Document title: EIA Addendum

Client	WuXi Biologics Ireland Limited
Project	Effluent Balancing And Resource Recovery System
Job number	100085897

As requested by LCC, recommended design changes and mitigation measures featured in this report have now been incorporated into the refined design layout. All revised planning drawings are presented in Appendix 1.3.

2 BALANCE & OFF SPEC TANKS LOW LVL PLAN
1 : 100

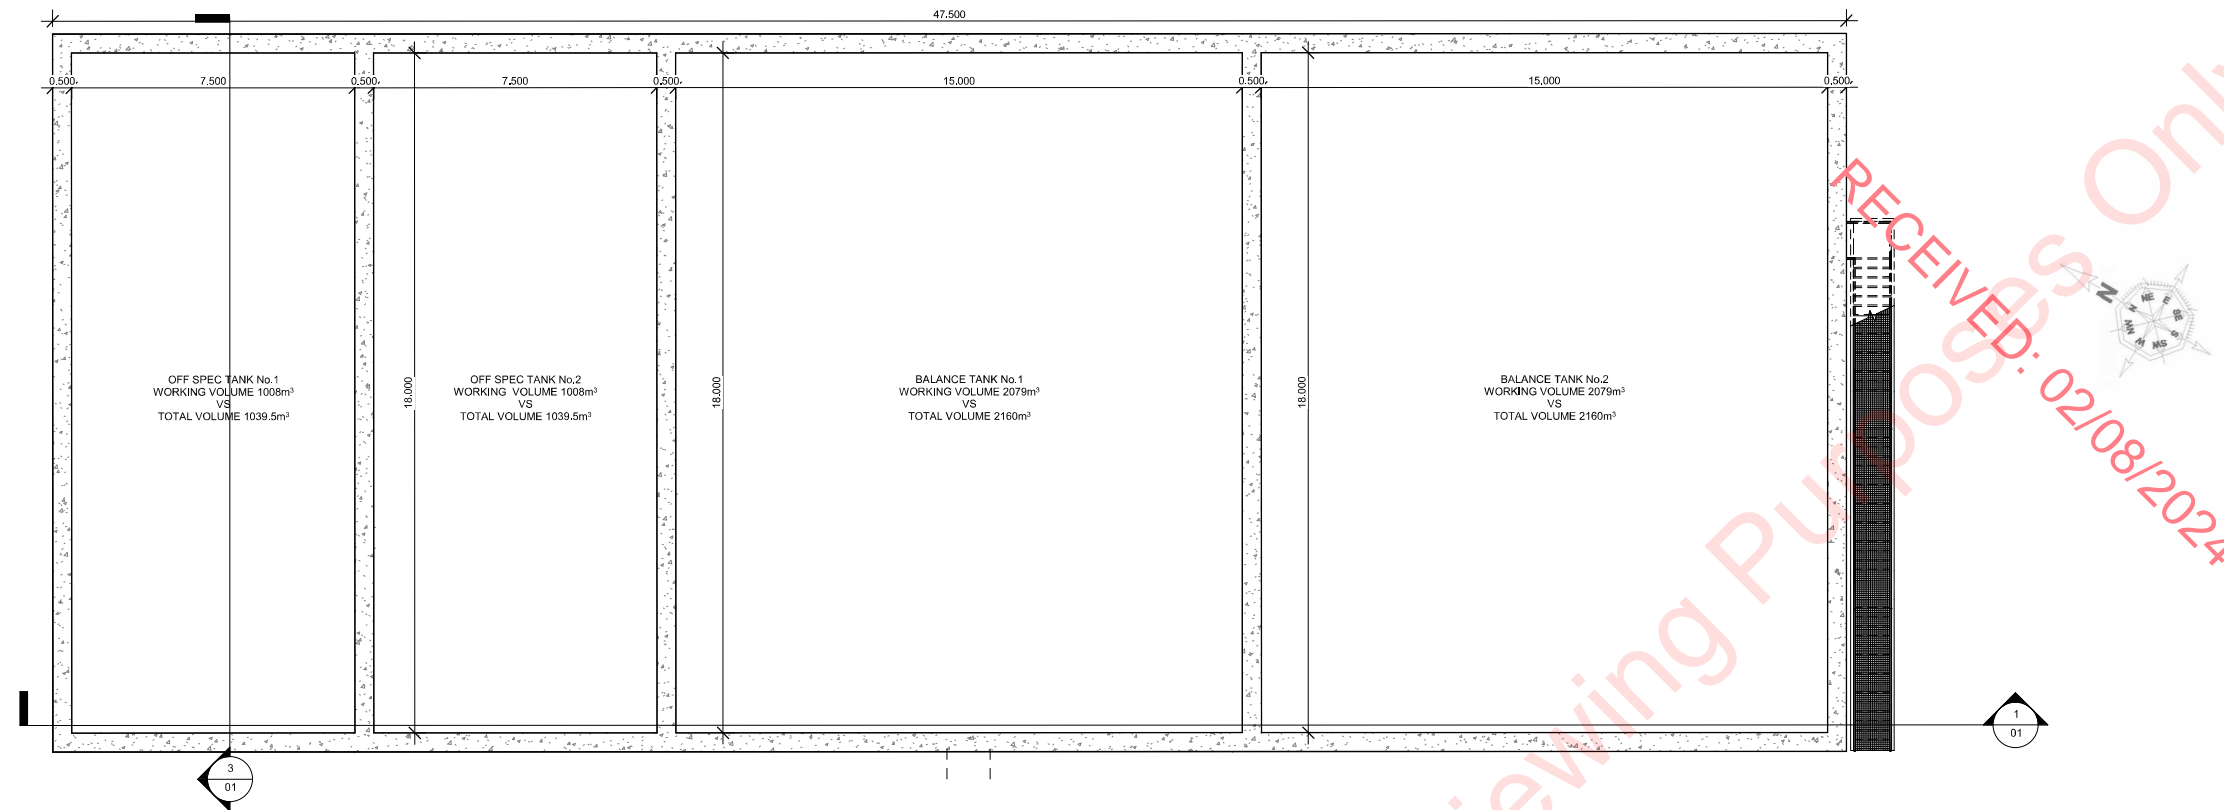
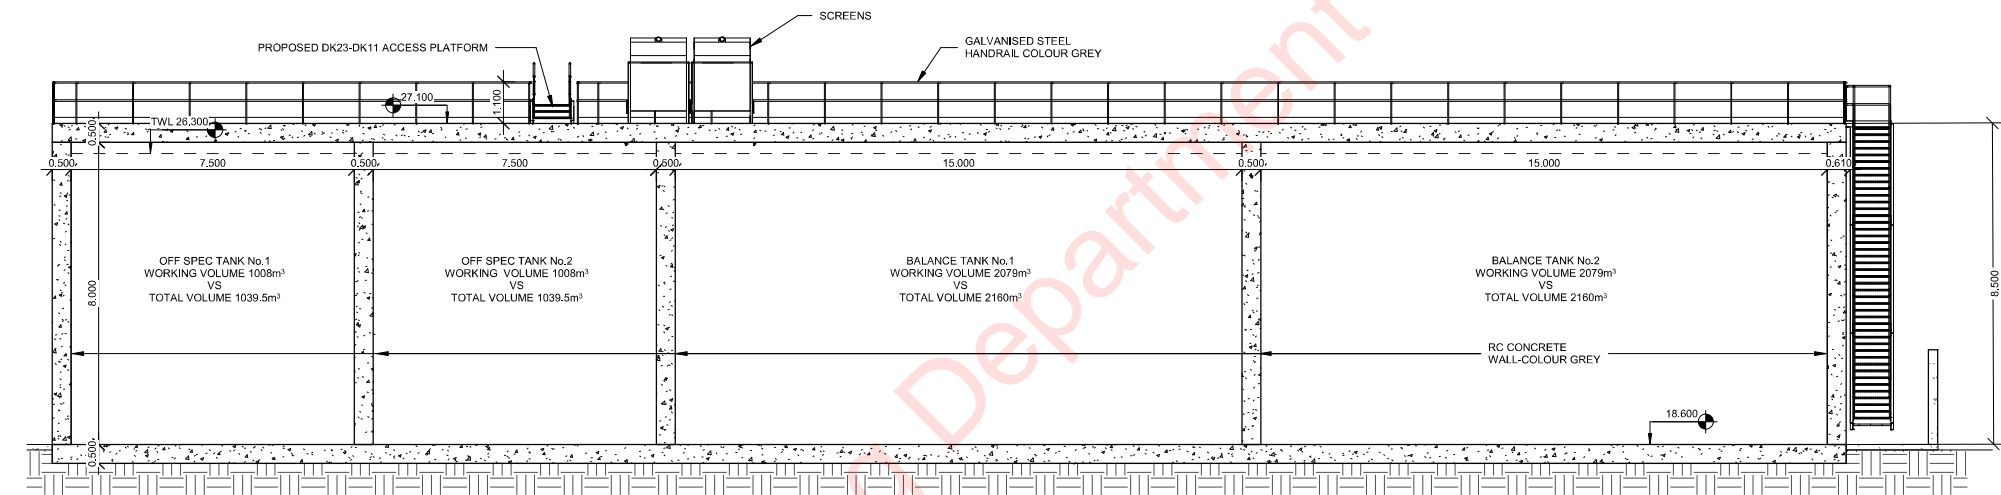
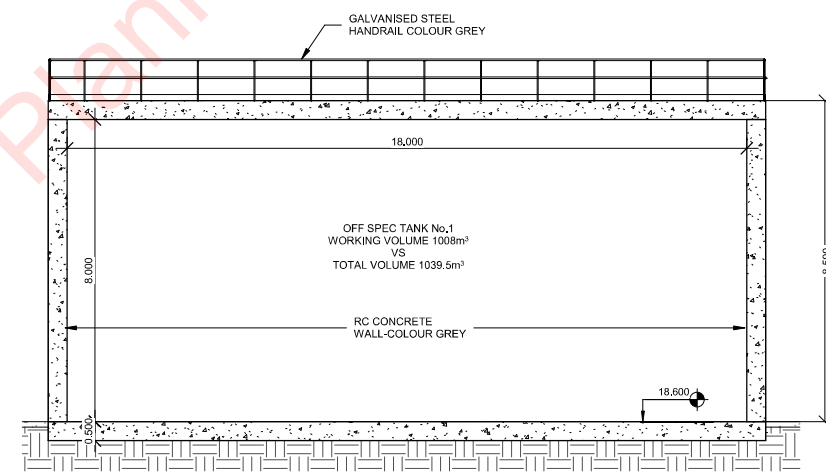
The balancing tanks and off specification tanks dimensions have been reworked from 6no. cells with overall external dimensions of 54.2m x 16.3m x 7.6m to 4no. cells with overall external dimensions of approximately 47.5m x 19m x 8.5m (including roof slab but excluding base slab).

In order to maintain a similar volume capacity to the tanks in the original design, the balancing and off-specification tanks are approximately 1m higher than in the previously submitted planning drawing package to LCC. The proposed roof level of 27.1mOD is still below the membrane building ridge level of 27.651mOD, however it is above the administration building ridge level 26.042mOD. It should be noted that the new proposed balancing tank and off specification tank roof level do not exceed the roof level of 27.50mOD, previously proposed for the aeration tanks.

1 AERATION TANK, ANOXIC TANK & SLUDGE TANK PLAN
1 : 100

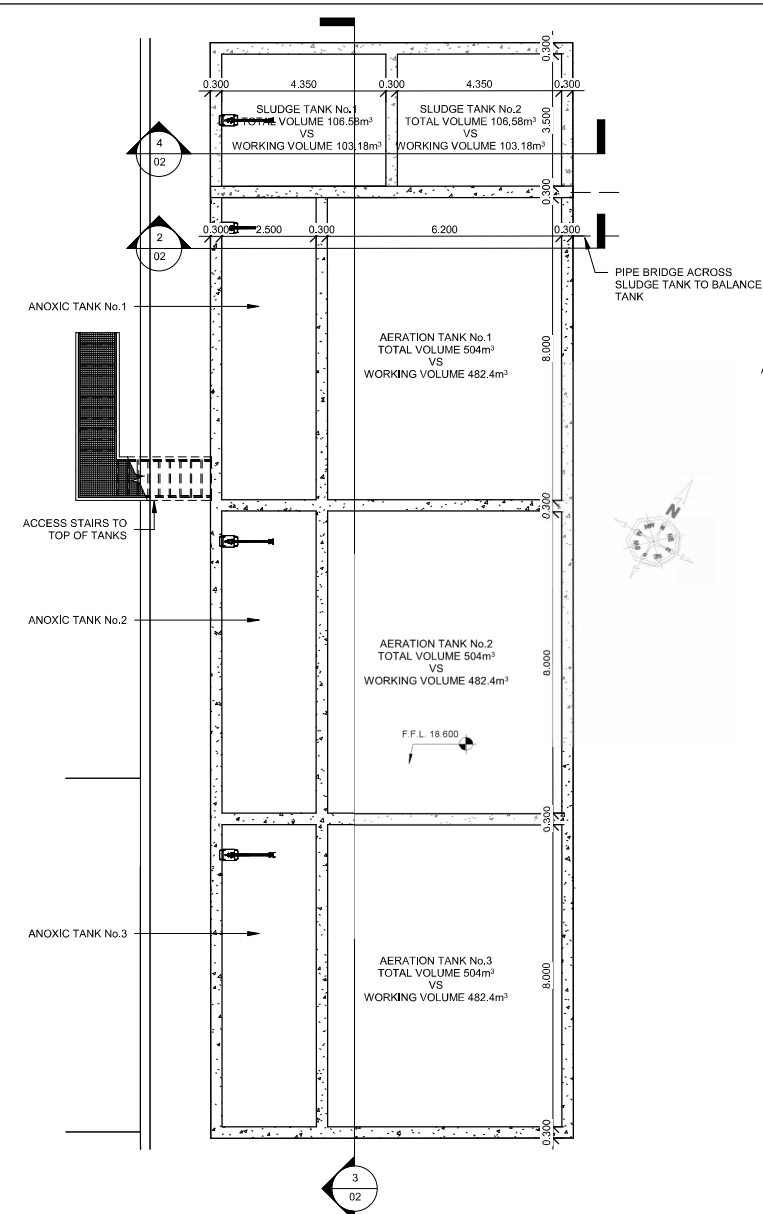
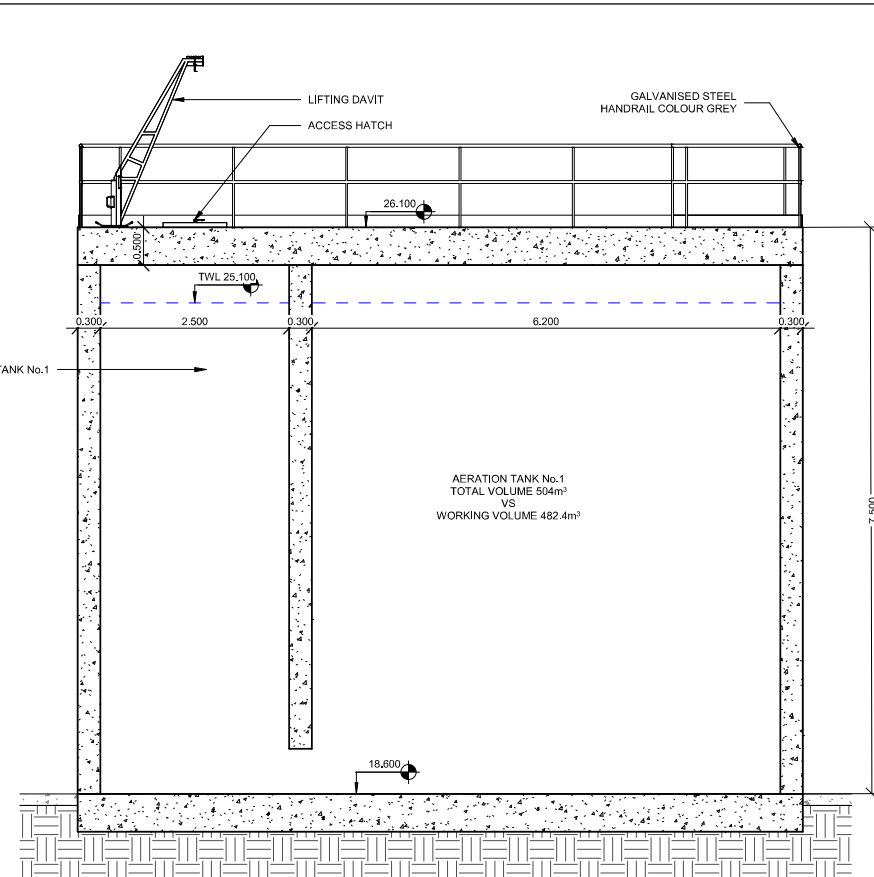
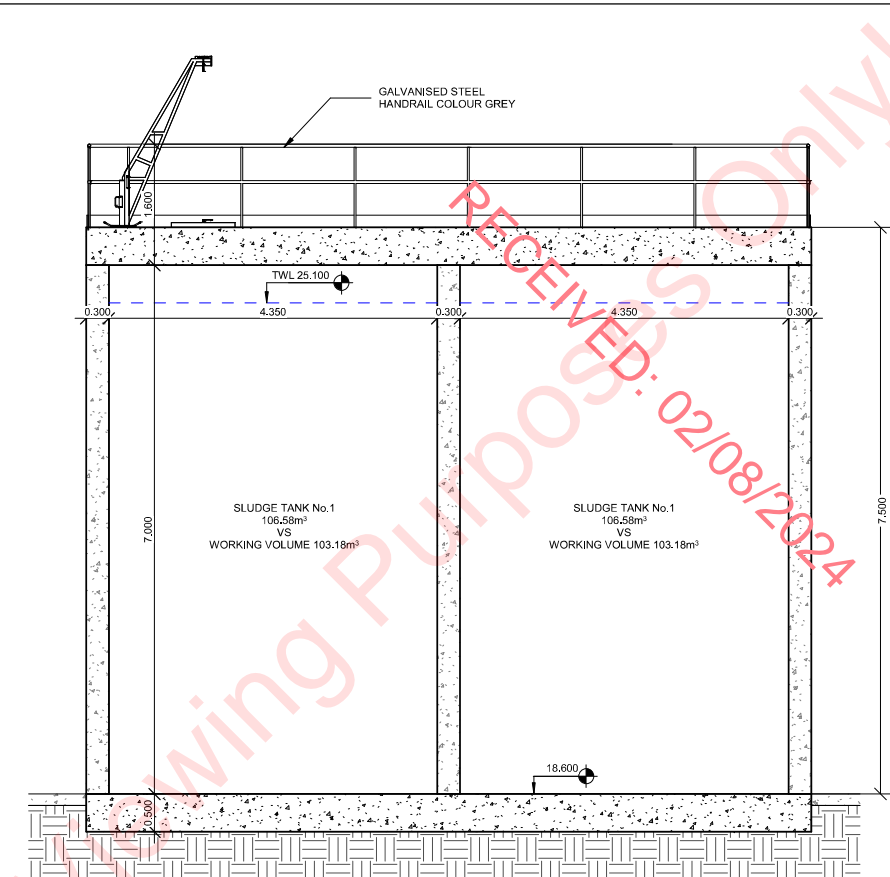
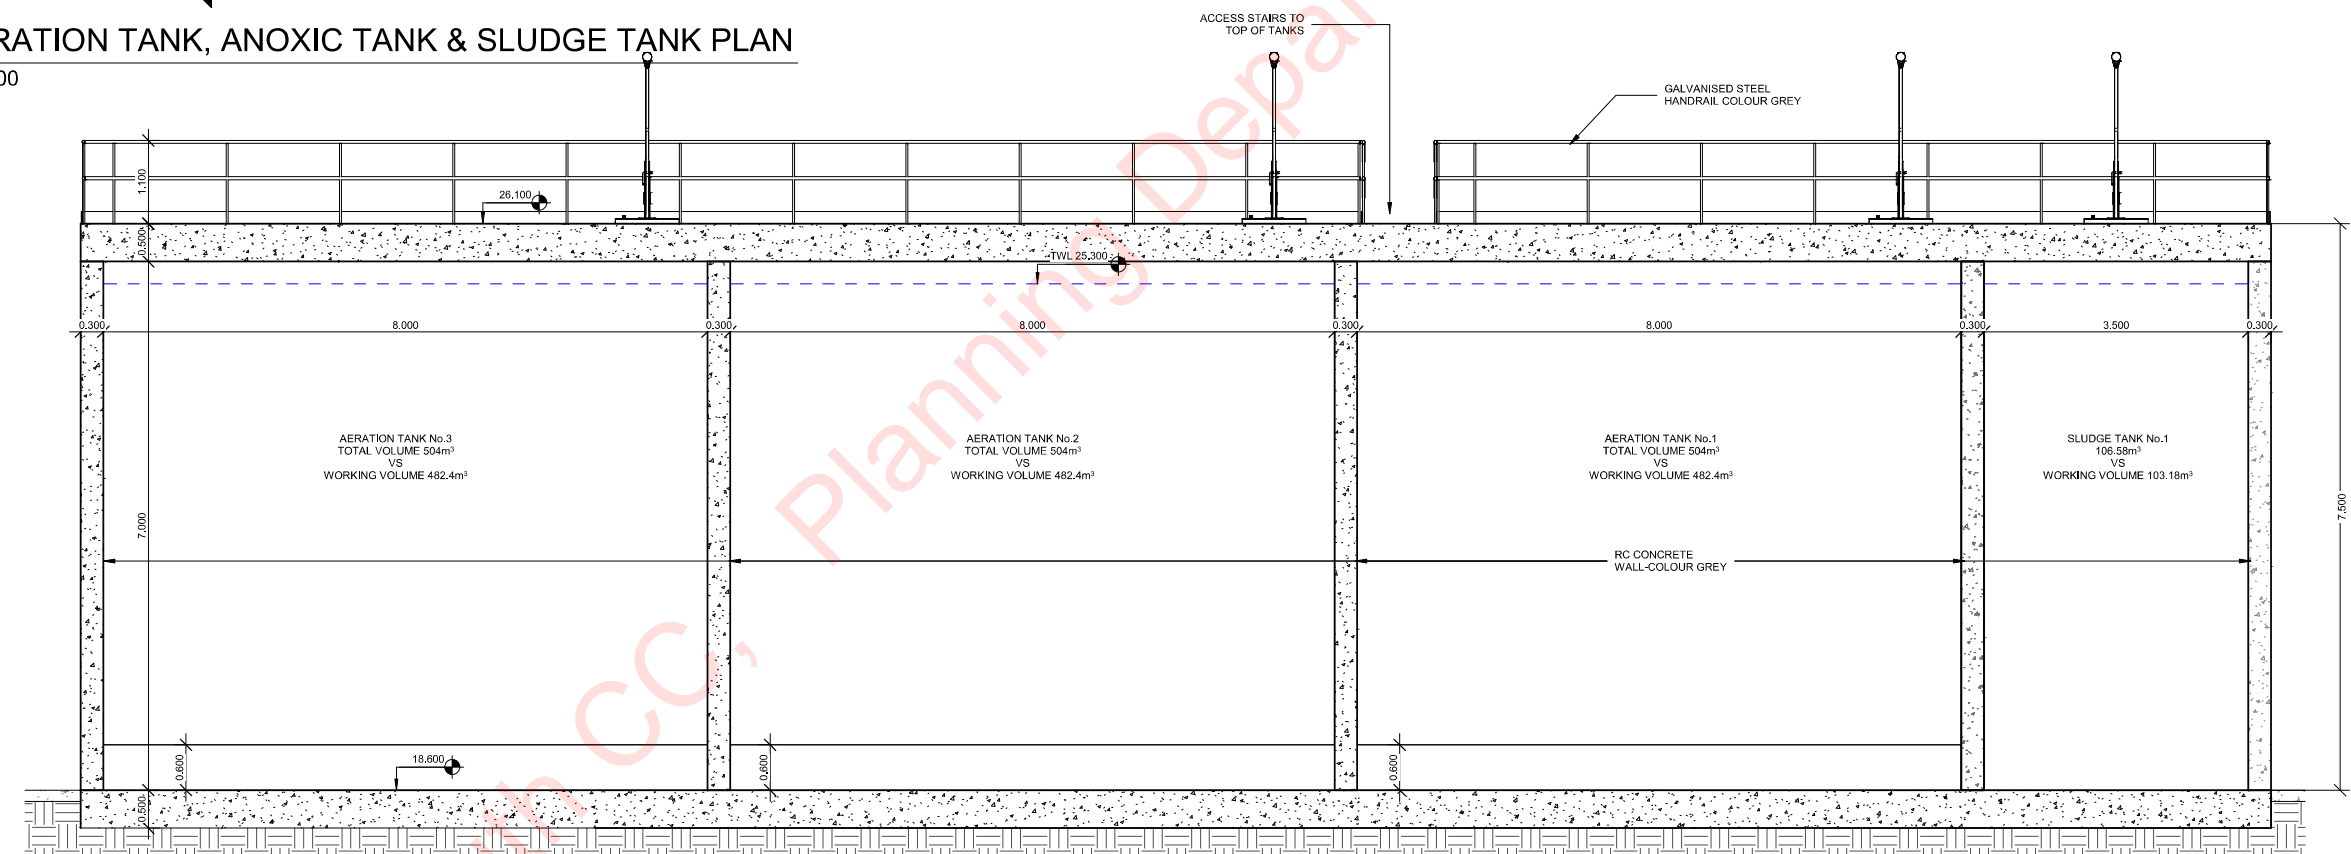
The sludge buffering tanks were incorporated with the aeration tanks in a common structure with internal dividing walls to optimise site footprint and ensure that the Recorded Monuments and identified archaeological features and deposits located within the site of the proposed development will not be impacted.

The aeration tanks dimensions within the new overall structure is approximately 25.2m x 9.6m x 7.5m (not including base but including for roof slab). To facilitate this optimisation of the required infrastructure, the process is operated at higher MLSS levels within membrane supplier recommendations.

The aeration tanks have been shifted slightly south from their original location, however the tanks should remain mainly screened by the building as their new estimated top of wall level of 26.1mOD is below the ridge level of 27.651mOD of the membrane building and below the ridge level of 26.042mOD of the administration building. The top of handrails are between 27.2m and 27.7mOD and therefore slightly above the ridge level of the administration building, however this was already the case in the planning drawing, where the top of handrail was at 28.6mOD and therefore 0.949m above the ridge level of the membrane building.

The sludge buffering tanks have been relocated north of the aeration tanks and combined into a common structure. The tanks are screened by the membrane building as detailed above.

The new sludge buffering tanks constitute a 3.8m x 9.6m x 7.5m section within the overall combined 29m x 9.6m x 7.5m (not including base but including for roof slab) aeration tanks/sludge holding tanks structure as detailed above. Please note that the sludge blending tank has been removed from the design and only 2no. sludge buffering tanks have been provided.

1 BUNDED AREA HIGH LVL PLAN
1 : 200

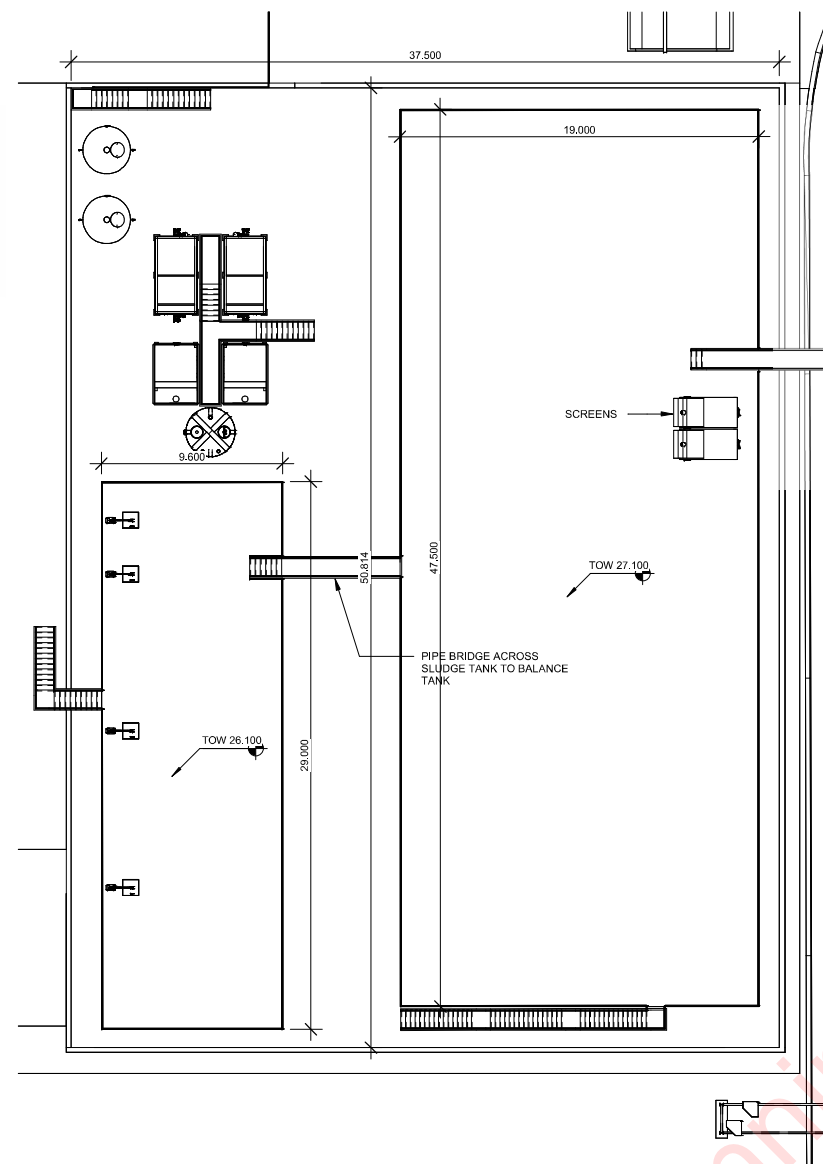
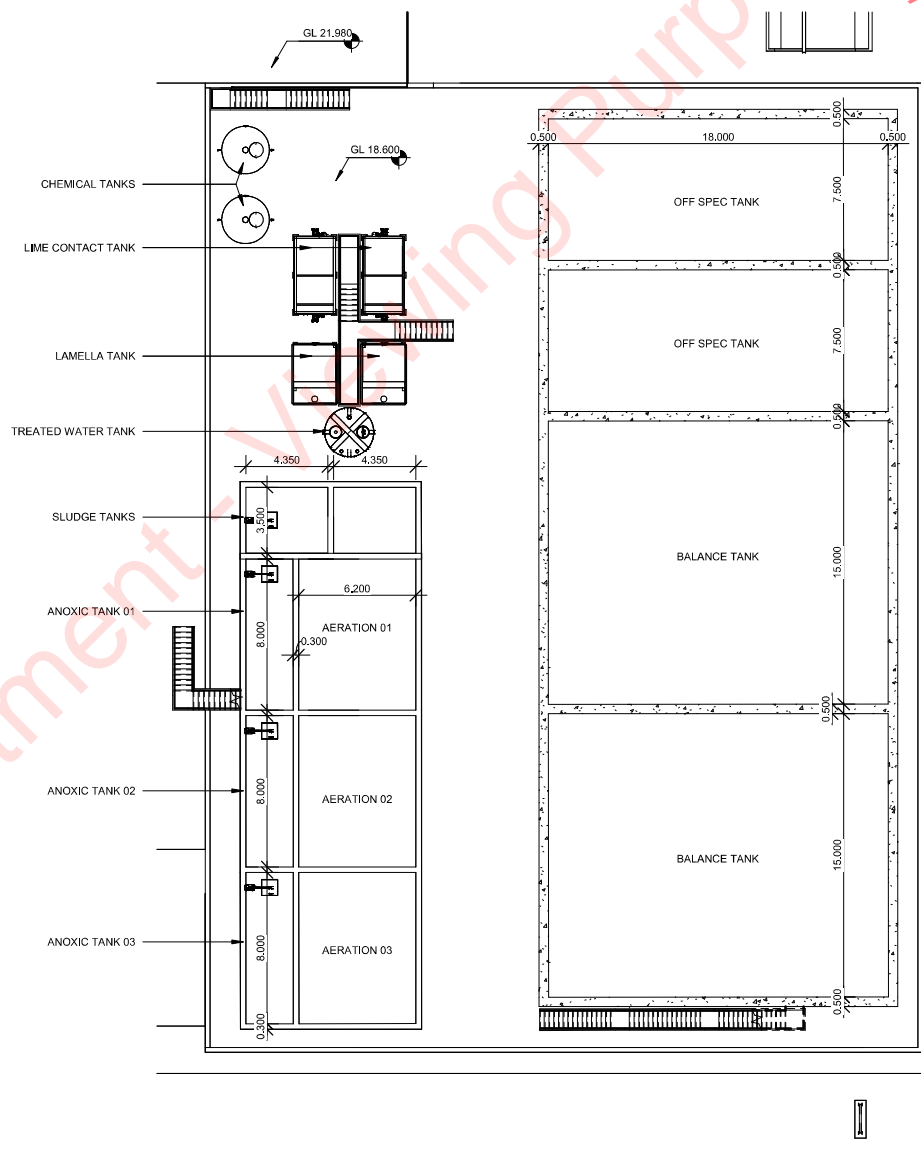
The overall bund has been rationalised and is smaller overall, although some small areas to the south which were not previously excavated form part of the bund to facilitate the above rationalisation.

The chemical delivery area has been moved further west in line with the reduction in bund footprint. The chemical storage tanks have been moved within the common bund.
